SUBJECT: Engineering Review Comment
Mountain View Electric Association Inc. (MVEA)

Project Name: Overlook at Homestead Filing 1 – Final Plat

Project Number: SF2425

OVERLOOK AT HOMESTEAD FILING NO. 1

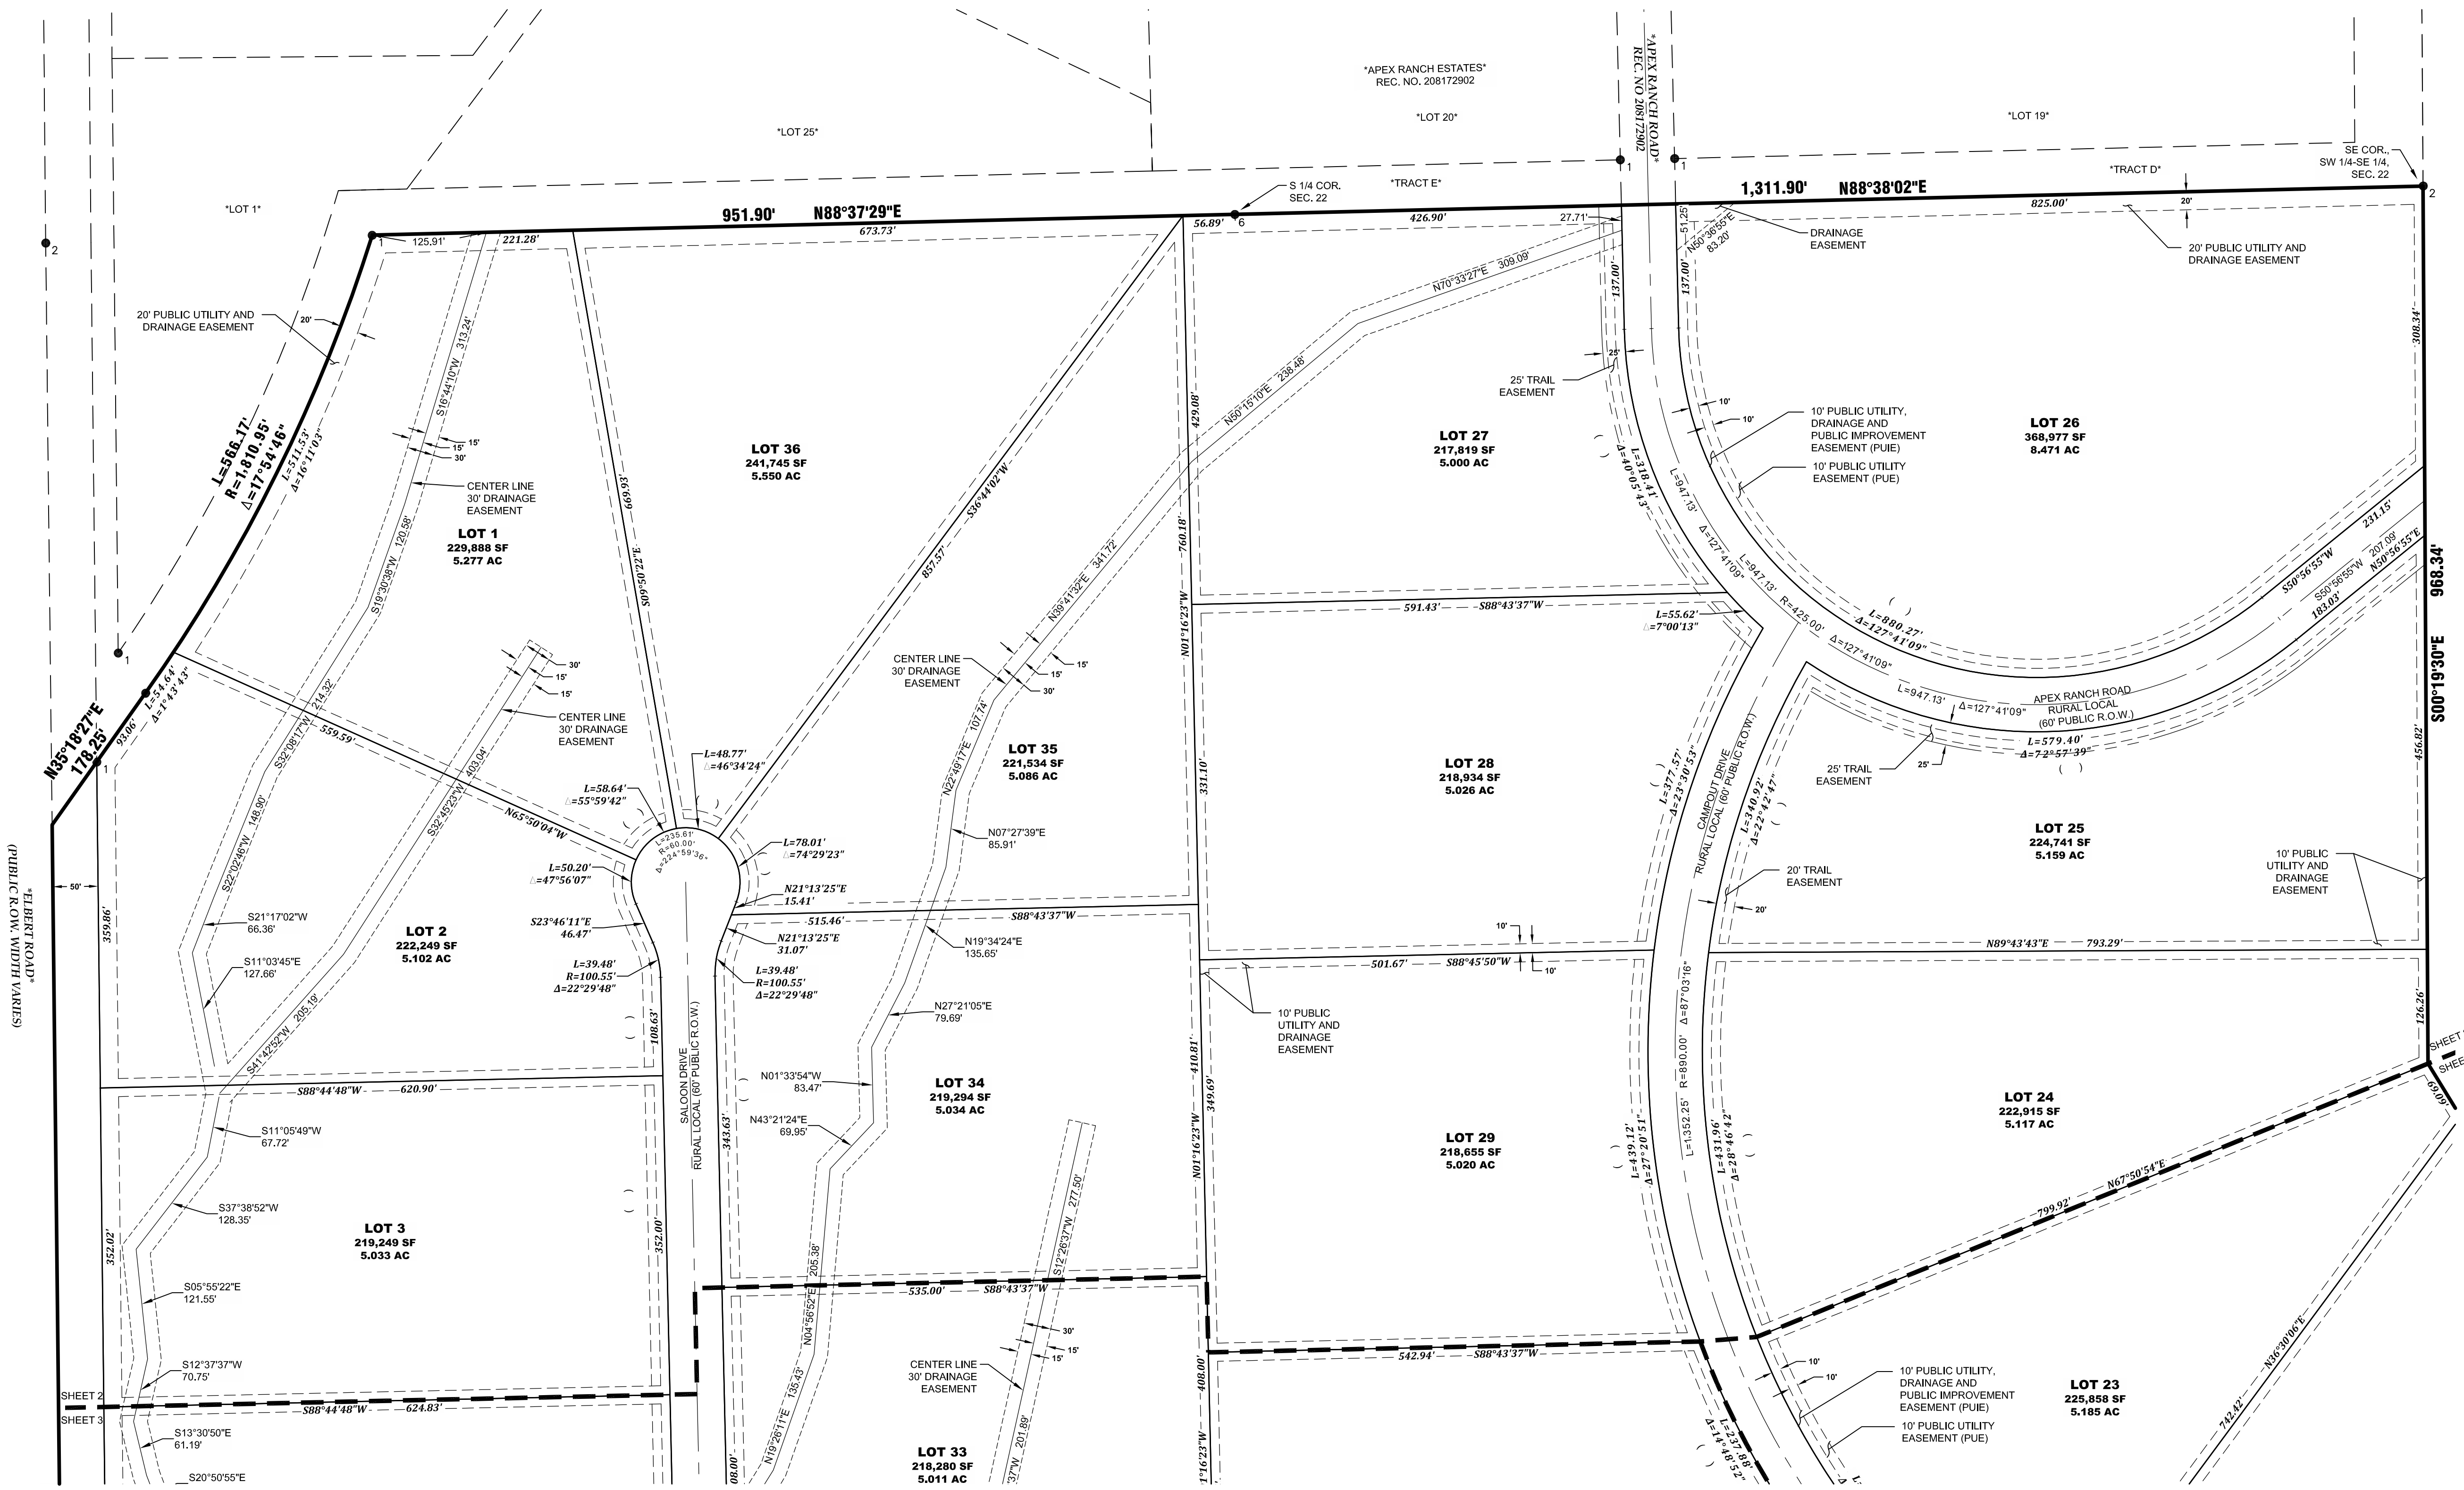
MVEA requests a ten (10) foot front, side, and rear lot utility easement and all tracts, along with a twenty (20) foot exterior utility easement on the plat. MVEA also requests the platting of MVEA's existing facilities with easements on the plat. Additional easements may be required.
